From: Simon Davis
Sent: 05 March 2018 16:23
To: 'Peter Davies'
Subject: RE: BN/43/17/DOC 4 Lake Lane

BN/8/18/NMA

Status: Preliminary	Drawing: Proposed Elevations 02	Project: 4 Lake Lane
Scale: 1:100 @ A3	Dwg No: 052-D-06 - REV 1	Address: 4 Lake Lane, Barnham, West Sussex
NOTE: This drawing is to be scaled for planning purposes only	Date: 02.09.2015	Client: Joanne Lee and Bill Hislop

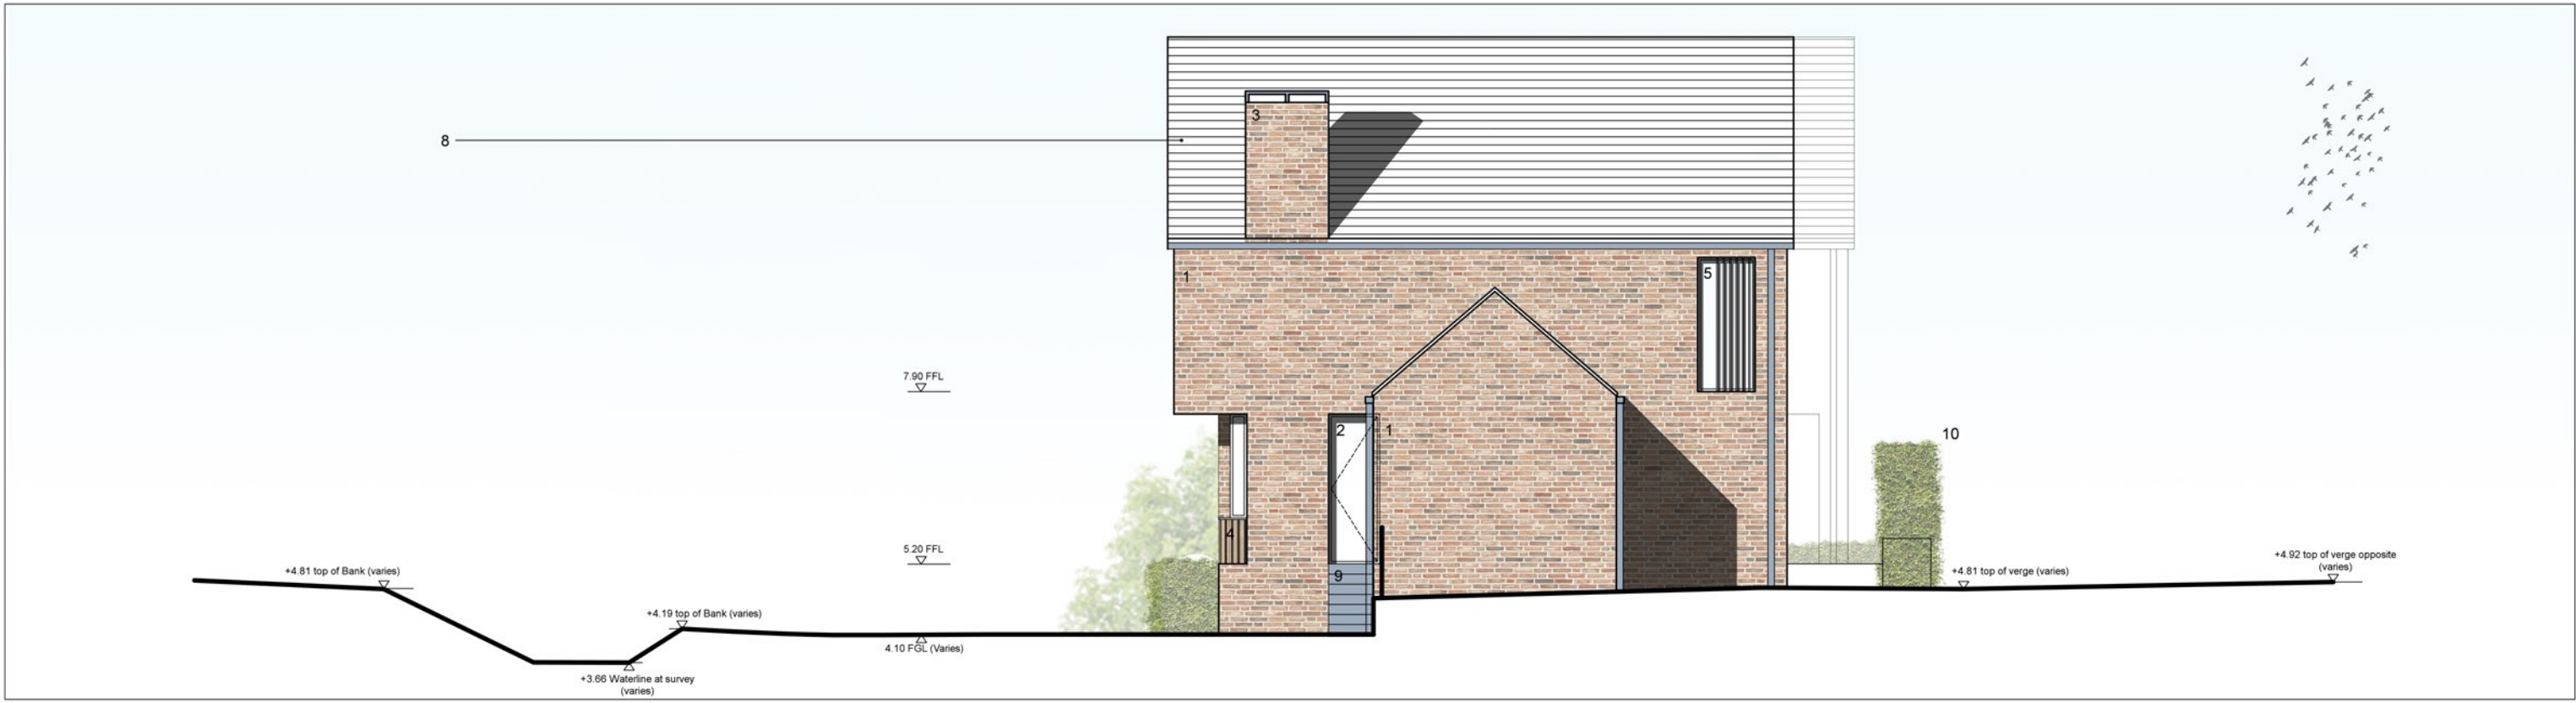
One small matter that has been brought to my attention by the roofing company. The gable verges are 'flush' gables. In that they appear to have no fascia or soffit detail. The undercloak caps onto the cut brickwork on the verge. The roofer says that this normally appears aesthetically better if the verge has a stretcher course of brick running up the verge. He says that the verge runs smoother, in a linear manner, rather than the verge resting on a cut brick which can look 'messy'. I have attached a photo showing that detail. We propose to run two stretcher bonds immediately under the verge, without a header course.

Also the fascia and soffit for the main roof isn't too clear. We propose a brick corbel so that the fascia and soffit run into the corbel. I have also attached a couple of photo's.

I would suggest that these changes are not material and therefore, we could grant an NMA if you apply for one.
